Portishead Branch Line (MetroWest Phase 1)

Planning Inspectorate Reference: TR040011

9.3.7 ExA.SoCG-NSLIDB.D3.V2 - Statement of Common Ground

Between:

2.49 to 2.51 - Sheepway Bridge Maintenance Compound and Interim Access Arrangements

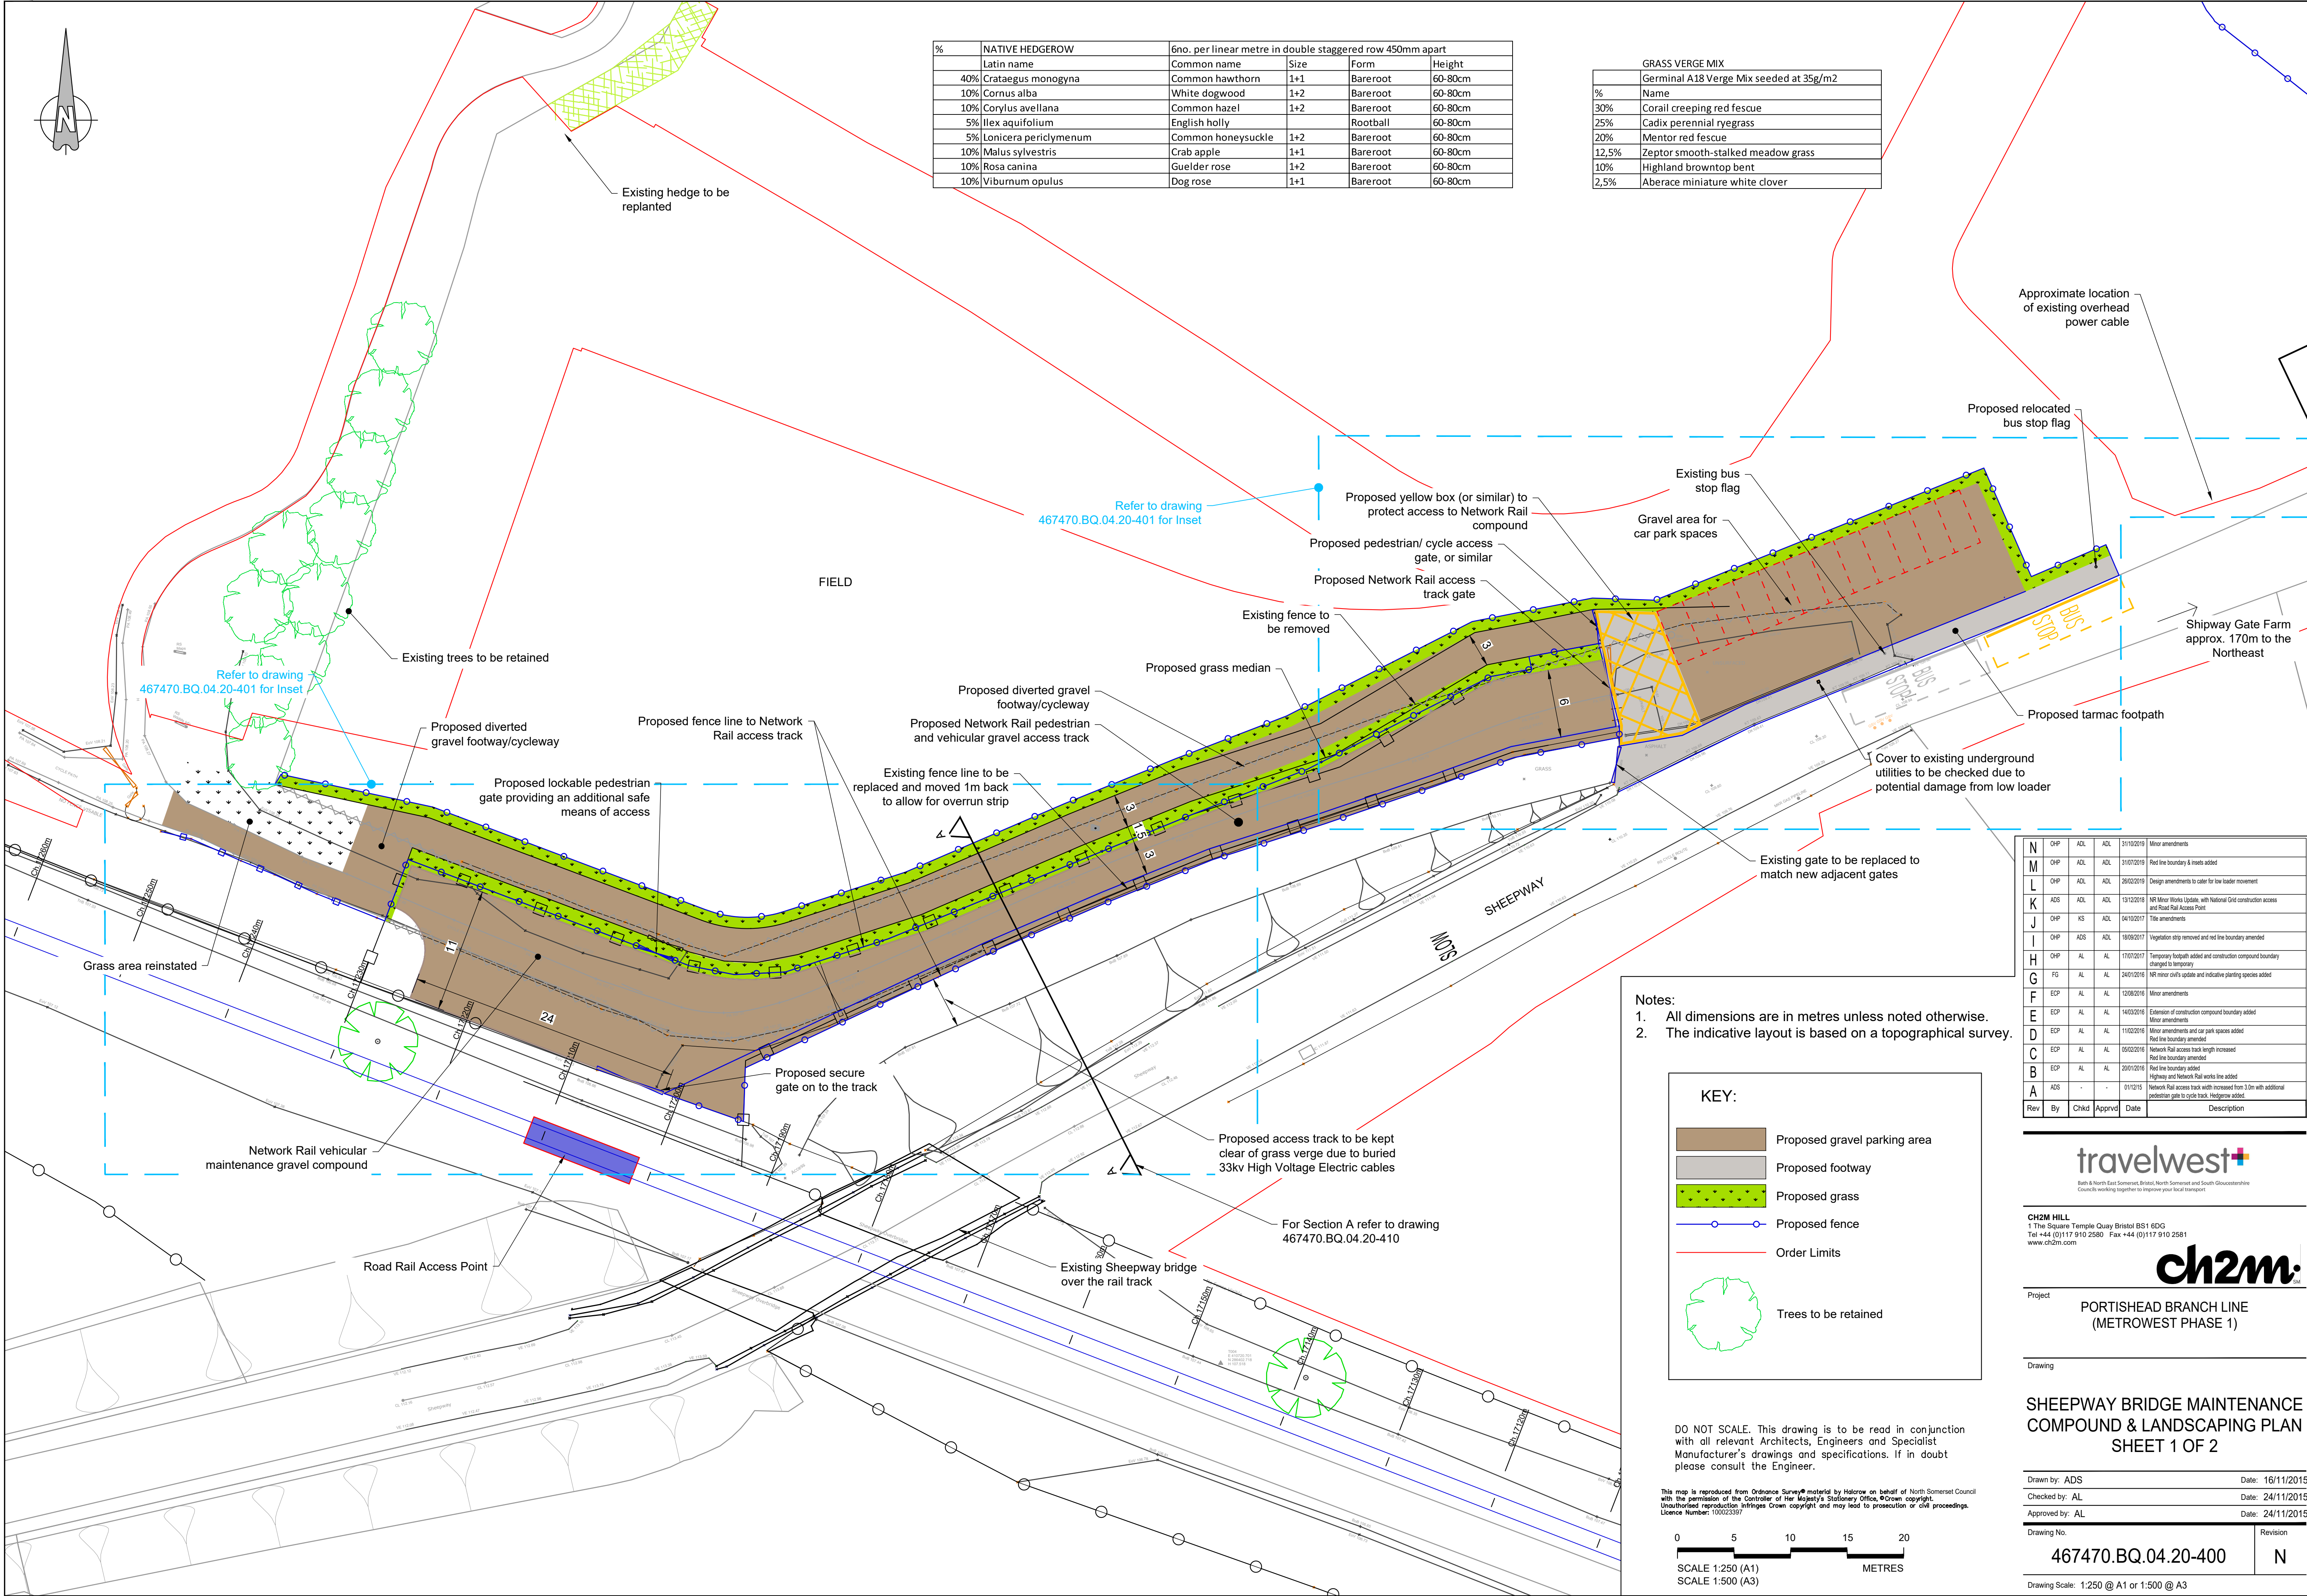
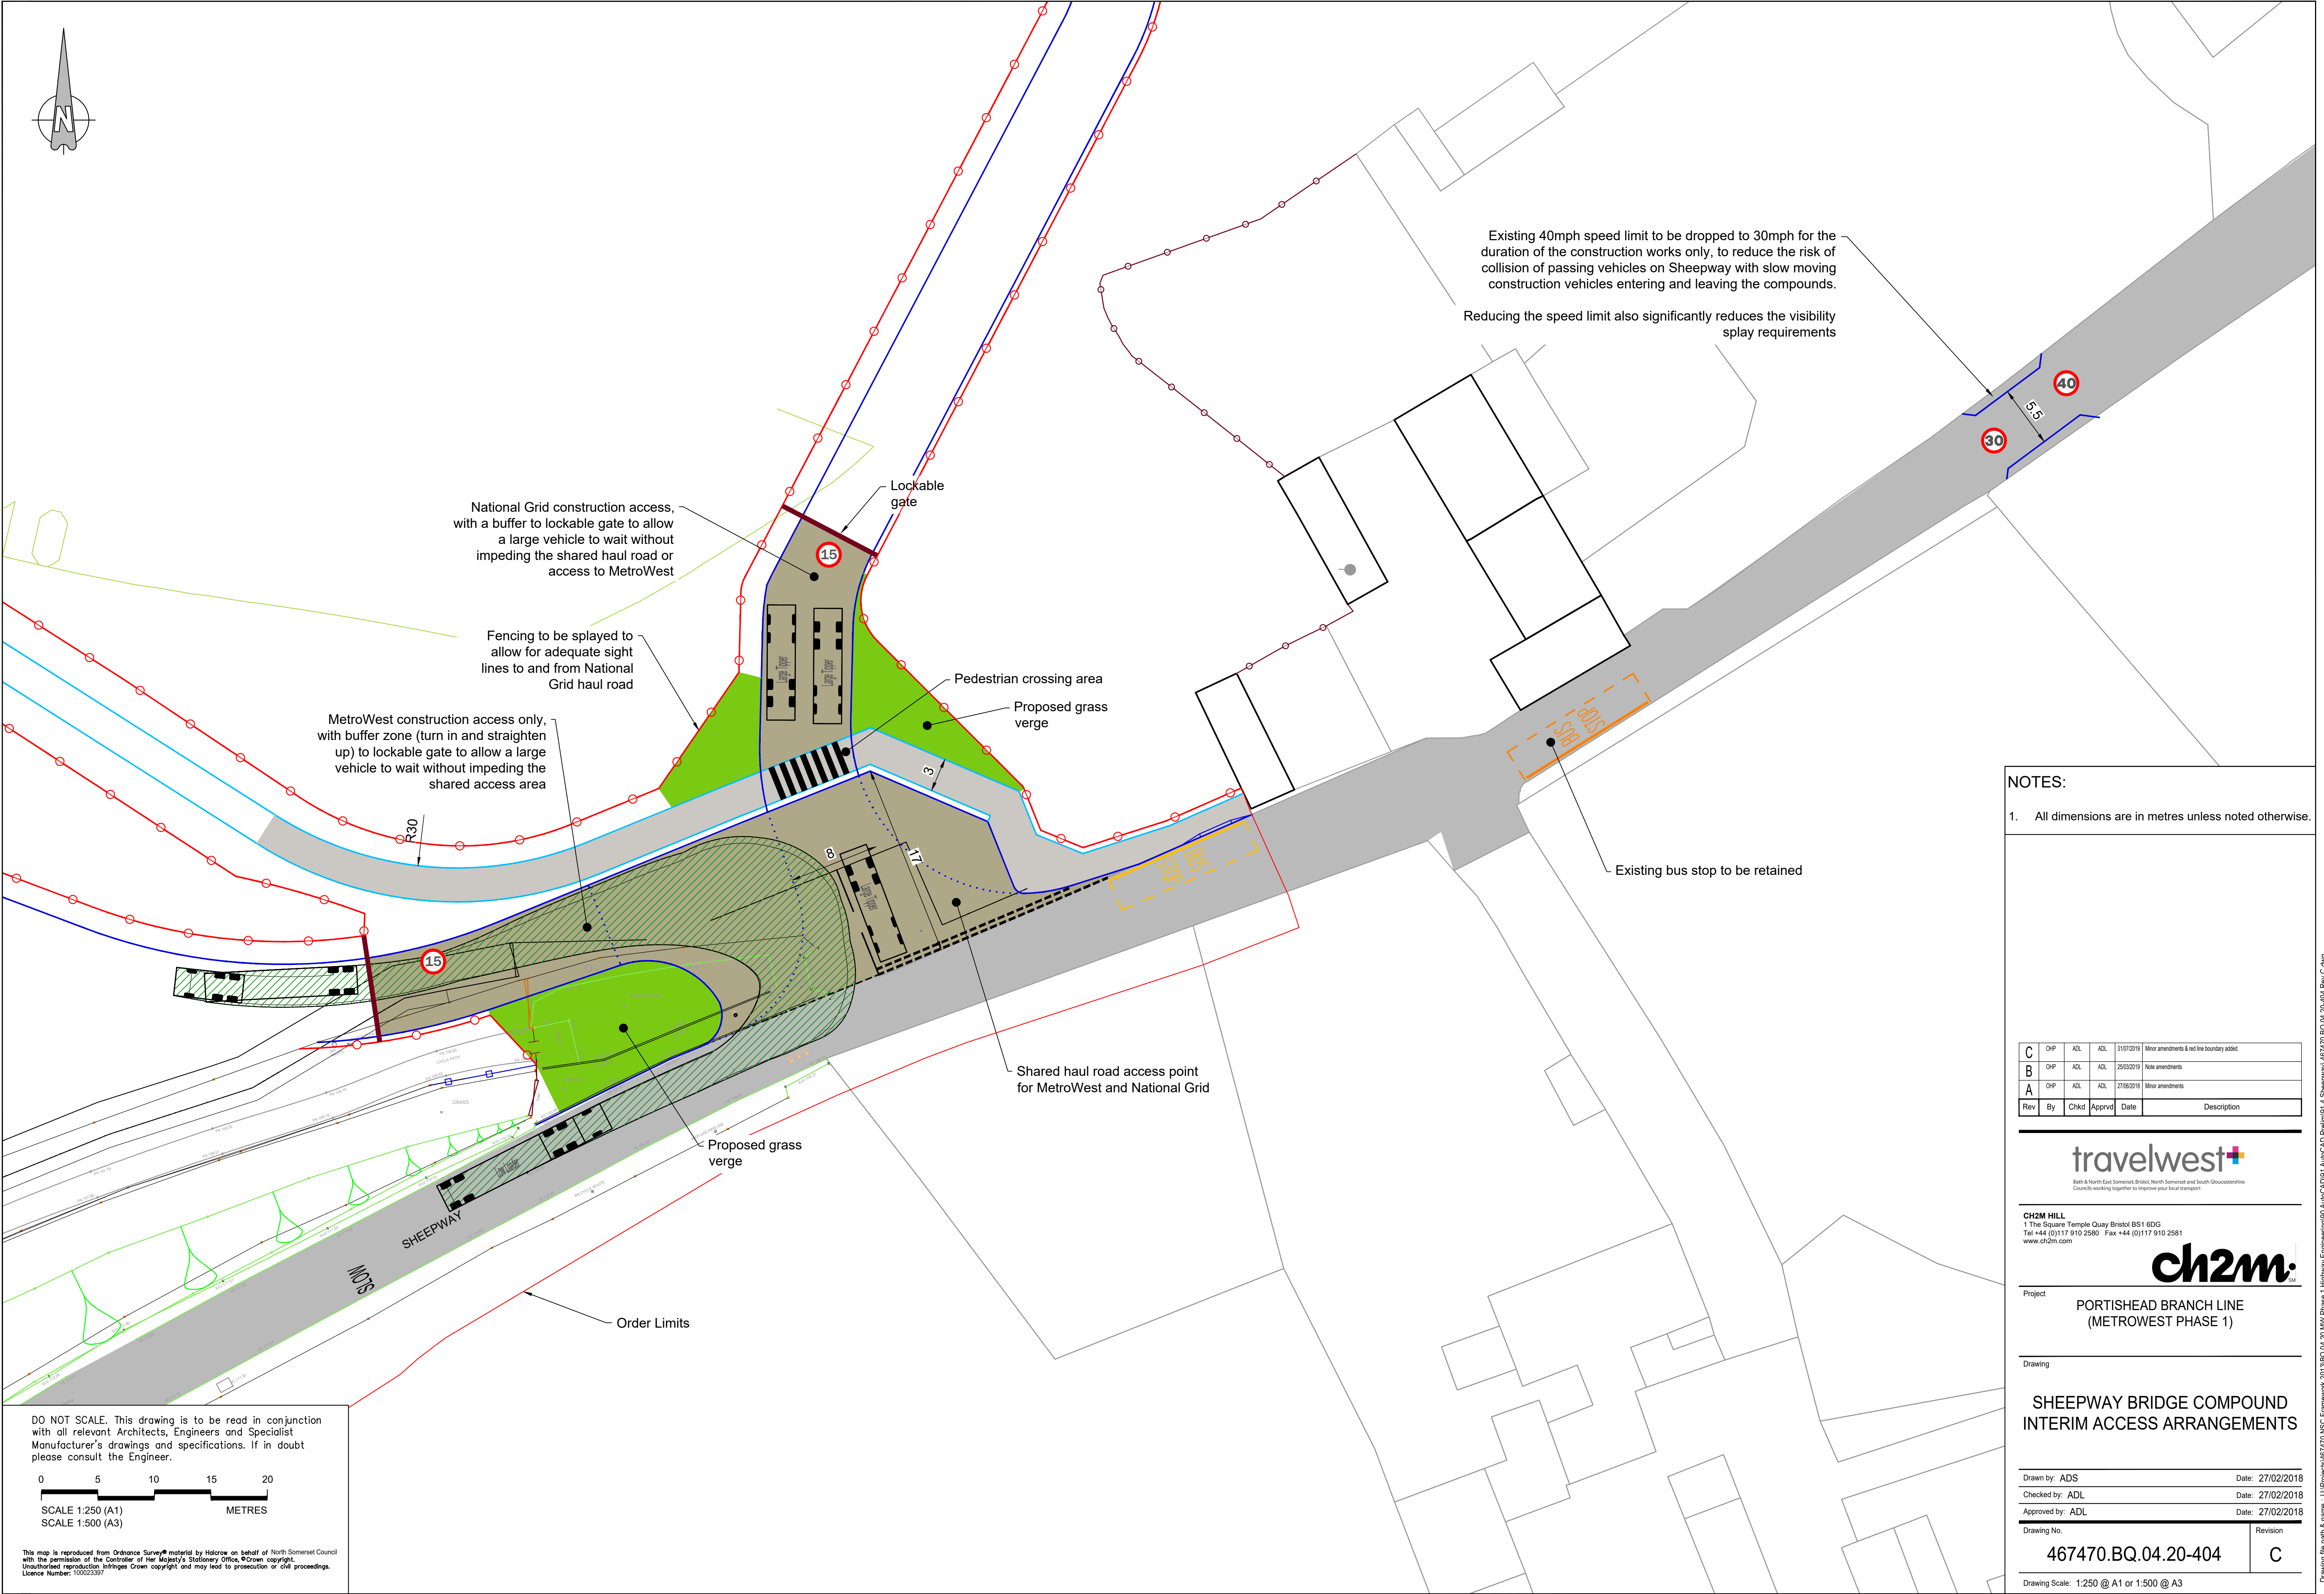
IDB1.10P	Water Resources , Drainage and Flood Risk	Stated a need for a method of the NSLIDB legally securing access to the proposed NR compound at Sheepway.	The latest highway drawing (DCO Document Reference 2.49) for the Sheepway area was issued to the NSLIDB and it was stated that there may have been a misunderstanding between what NR need on a temporary and permanent basis. On a temporary basis (during construction) the NR compound will indeed prevent access for the NSLIDB. However, post-construction the existing access route that the NSLIDB has used in the past in that location will be reinstated, albeit in a slightly different alignment to go around the NR compound track. We believe this represents a betterment on	Agreed
		Sneepway.	have been a misunderstanding between what NR need on a temporary and permanent basis. On a temporary basis (during construction) the NR compound will indeed prevent access for the NSLIDB. However, post-construction the existing access route that the NSLIDB has used in the past in that location will be reinstated, albeit in a slightly different alignment to go around the NR compound

NSDC currently clear the ditches in this area and will be able to do so during construction as they use a different access from the north west (via

Portishead) – this separate access will be unaffected by the DCO Scheme.	
IDB1.11P	Water Resources , Drainage and Flood Risk	Requested location specific outfall details of temporary and permanent drainage features that include invert levels and a check on the downstream connectivity of the receiving watercourses. Stated all that currently appears on drawings is an indication of flow rates; however, stated that the flows are acceptable.	The detailed design stage will be completed when it is known what the contractor's plans are for using the haul roads and compounds. The Surface Water Drainage Strategy (DCO Application Document Reference 6.26) has assumed a worst case (i.e. 100% coverage with an impermeable surface) which in reality is unlikely to be the case, in the calculations.	Agreed
IDB1.12P	Water Resources , Drainage and Flood Risk	Requested details of temporary culverts for the haul road, compounds, site construction areas etc. with location specific sizes and invert levels.	This level of detail is not available until detailed design as it will need to be provided to the contractor with options as to how they deliver the scheme with the land available. The Surface Water Drainage Strategy (DCO Application Document Reference 6.26) sets out a worst case scenario for flow rates and suggested ways to manage the flows and the calculations and possible locations of these are contained within it.	Agreed
